**Consultation Response from KC,
Highways Development Management**

2025/93035 156, Hawthorne Way, Shelley, Huddersfield, HD8 8PX

Partial conversion of garage to living accommodation and associated alterations

Date Responded: 10/03/2026

part ground floor plan

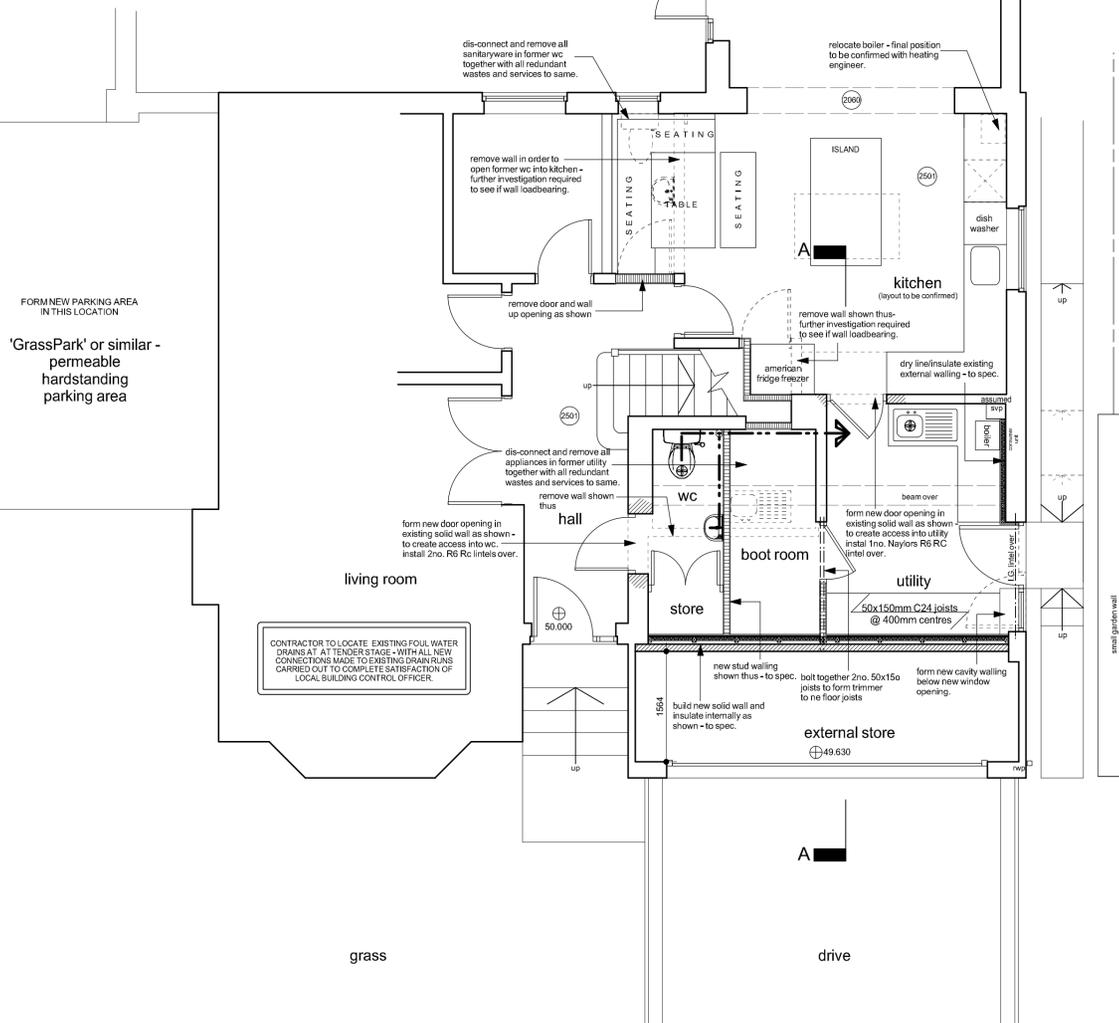
This application is for partial conversion of garage to living accommodation and includes for a replacement parking space to be located to the side of the dwelling at No 156 Hawthorne Way, Shelley,

The section of Hawthorne Way in question was a development by Redrow Homes (Yorkshire) Ltd and was adopted as highway maintainable at public expense on 26th November 2007.

The adoption included a 1.8m wide service margin adjacent to the property.

As a result, there is not sufficient width to provide a parking space as proposed within the curtilage of the property at this location and Highways D.M cannot support the application as submitted

There does appear to be space available at the front of the property for an additional space which could be provided by widening the existing drive.
